Consultation Response from KC, Highways Development Management		
2020/91978 22, Town Head, Honley, Holmfirth, HD9 6BW		
Part demolition of boundary wall to form new off road parking space (within a Conservation Area)		
Date Responded: 15/09/20	Responding Officer: CNB	Responding Ref: K3-41/37
This application is for the part demolition of a boundary wall to form new off-road parking with the access being made on to Town Head. Town Head is a two way single carriageway local link road of approximately 5m width with no footways and with street lighting present. The posted speed is 30mph but the actual speeds are expected to be lower than this due to the narrow road, on street parking and horizontal layout. There is evidence of on street parking occurring on Town Head as a number of the older dwellings don't have off street parking. There is a H-bar marking across an existing access immediately to the north of the proposal site. This access currently provides pedestrian access to a number of dwellings including No 22 and No 24, which would require pedestrian access across the proposed parking area. The proposals as shown in drawing 20 813 102 A are not expected to generate any additiona

Drawing Number_
20 813 102 A

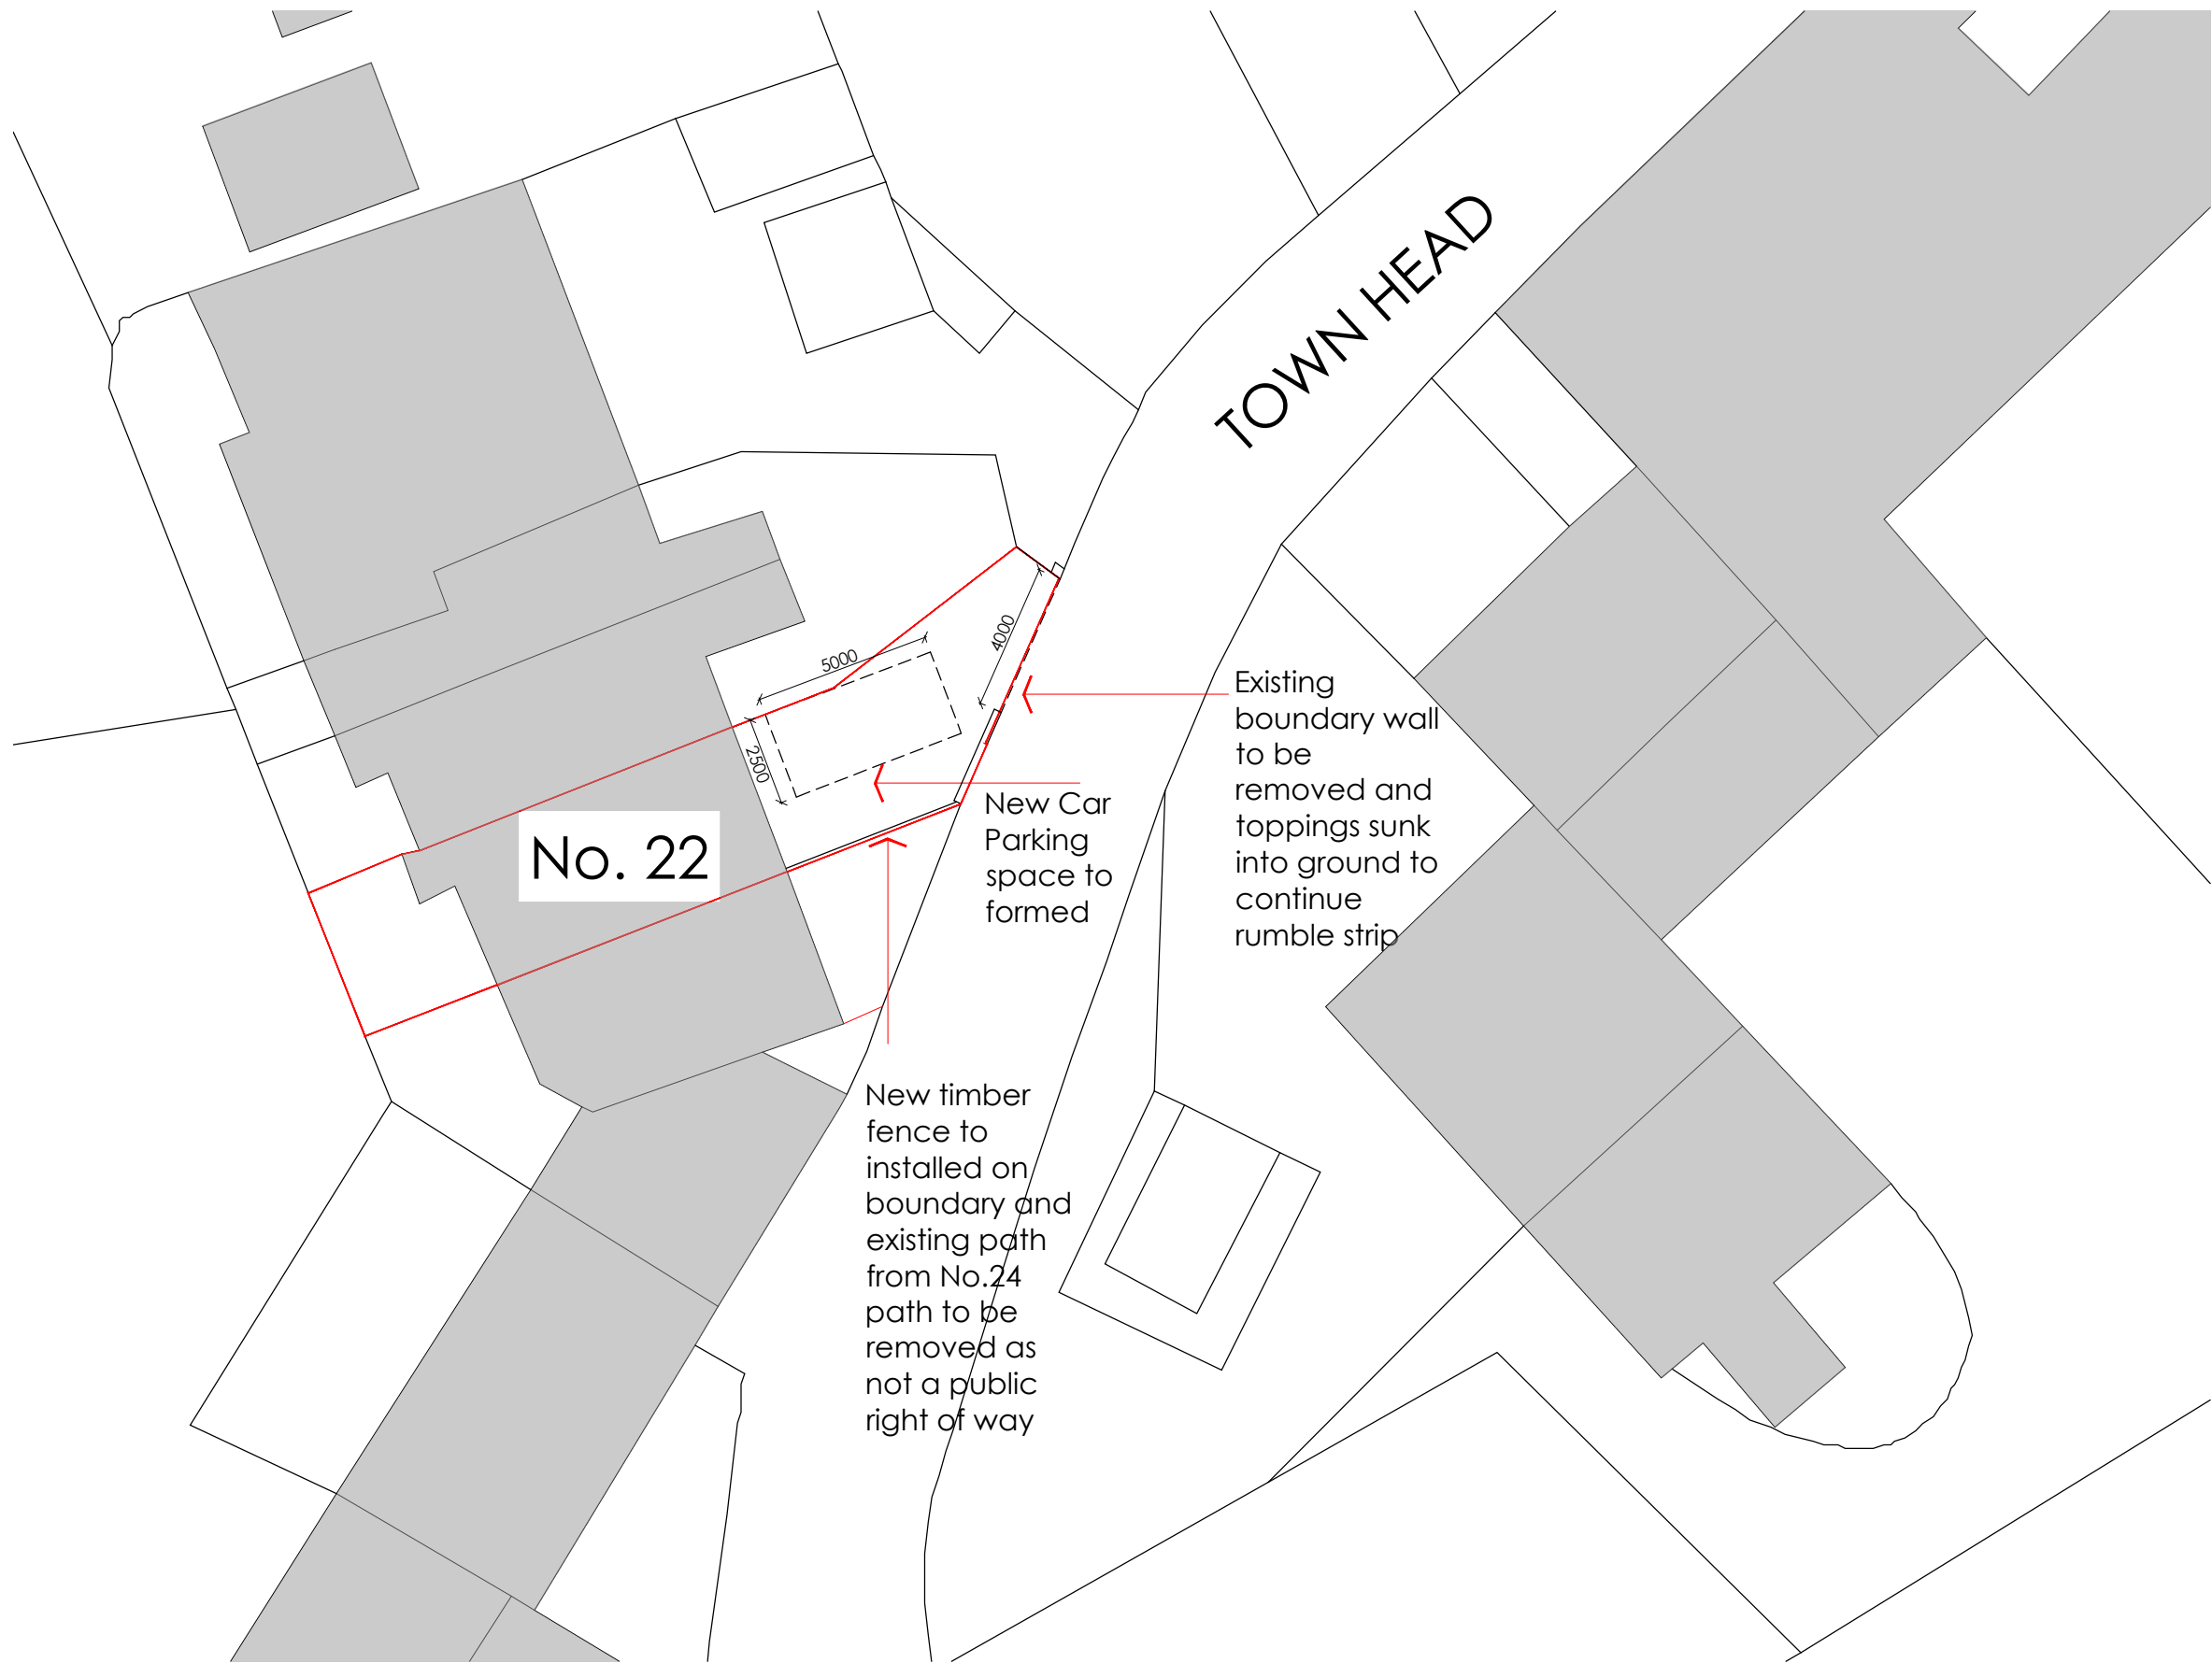
Drawing 20 813 102 A does not show the location of waste bin collection presentation points. This should be clearly indicated in such a location that it will not obstruct wither the access or the adopted highway for road safety reasons. This should be conditioned.

Drawing No 20 813 102 A indicates a timber boundary fence is to be erected to the boundary between 22 and 24 which would remove pedestrian access for No 24. This is not a public right of way and is a private agreement for access and not within the remit of this highways response. We would recommend that the applicant checks with their solicitor regarding this pedestrian route.

Before development commences, details of suitable storage, bin presentation points and access for collection of wastes from the dwellings hereby approved shall be submitted to and approved in writing by the Local Planning Authority. The approved details shall be provided before first occupation and shall be so retained thereafter.
